**WEST SUSSEX COUNTY COUNCIL
INFRASTRUCTURE CONSULTATION**

SUBJECT: FG/153/10-Application for a 12.8m skip to remain on property driveway & installation of 1 large hardwood, Iroko finish bi-folding gate to close off driveway.

52-56, Ferring Street, Ferring, West Sussex, BN12 5JP

GROUND FLOOR PLAN 1:100 Proposed

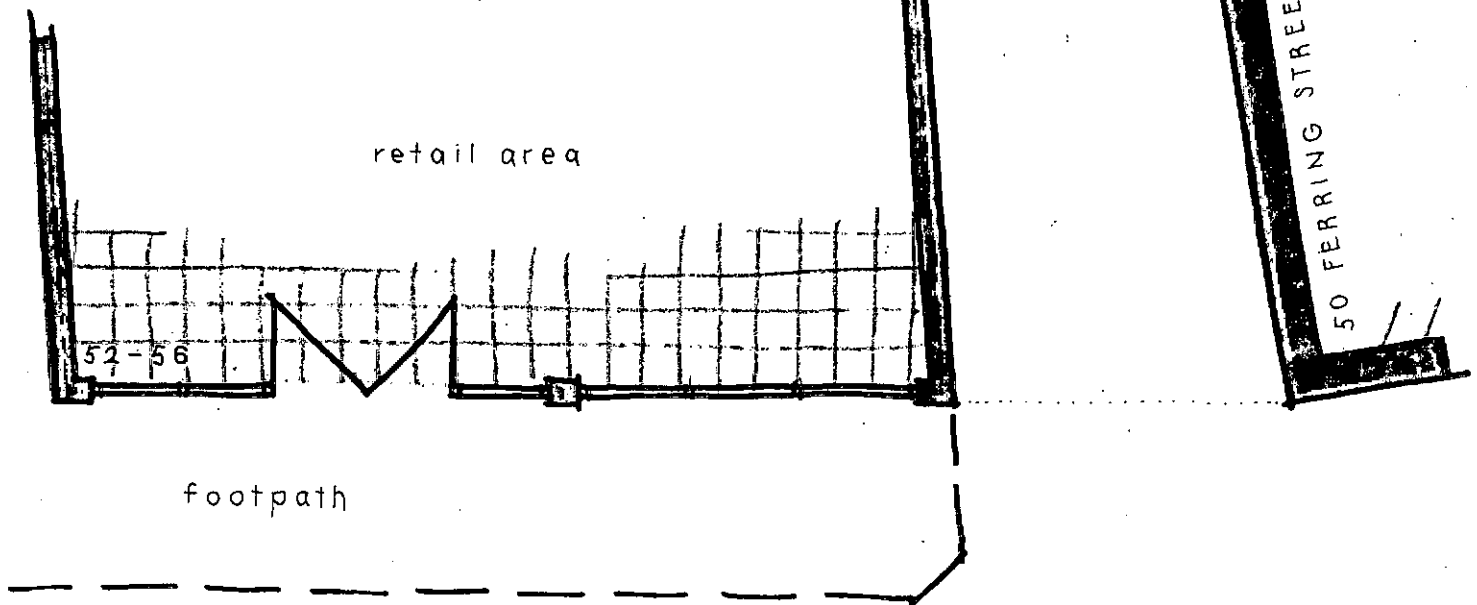
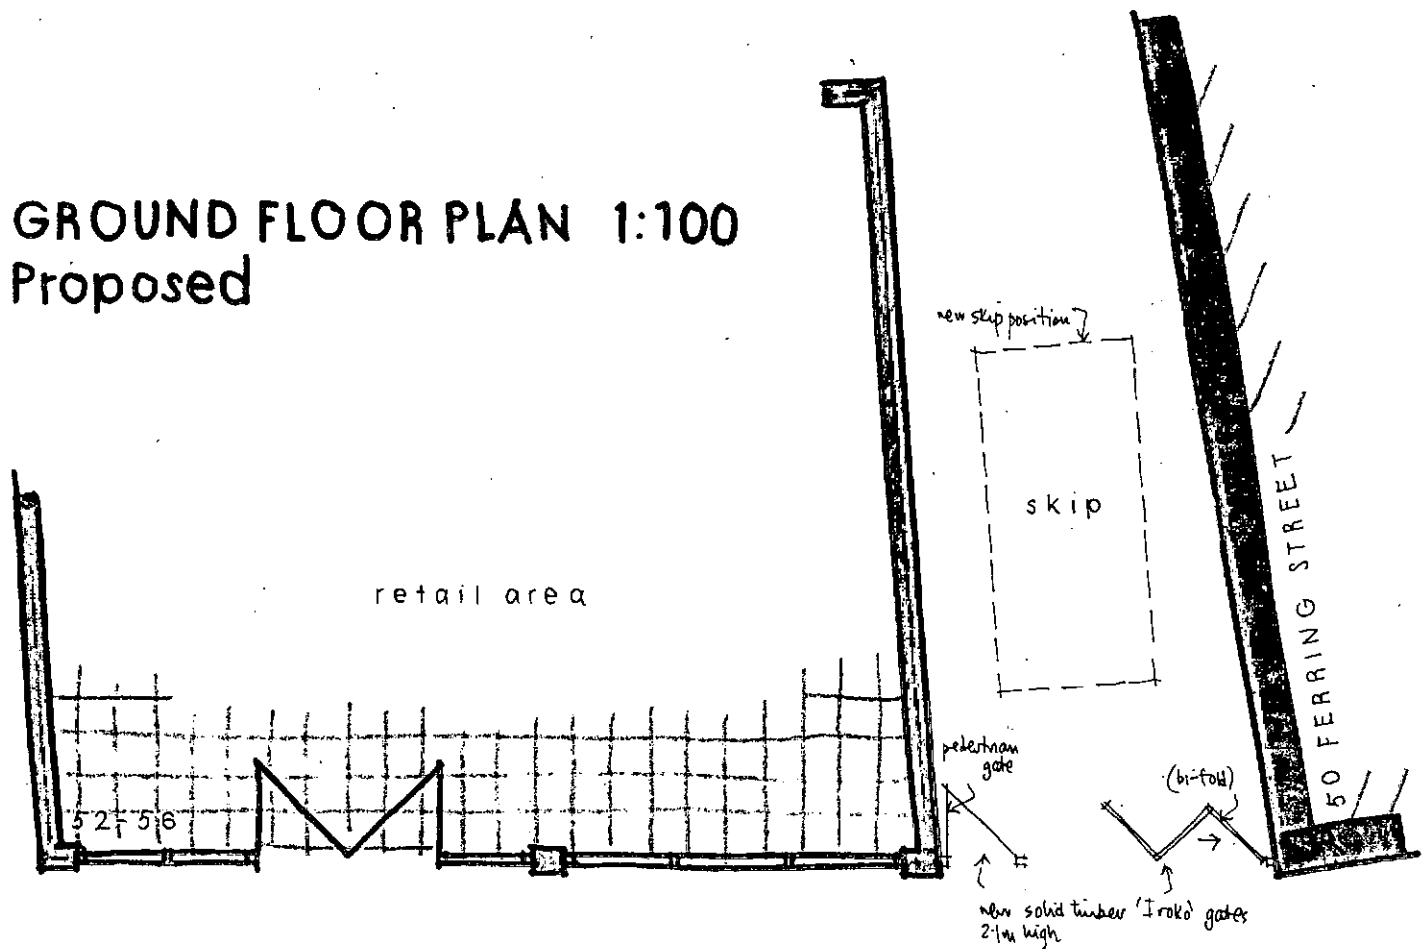
No concerns would be raised with this proposal on the understanding that the gates will open inwards of the site.
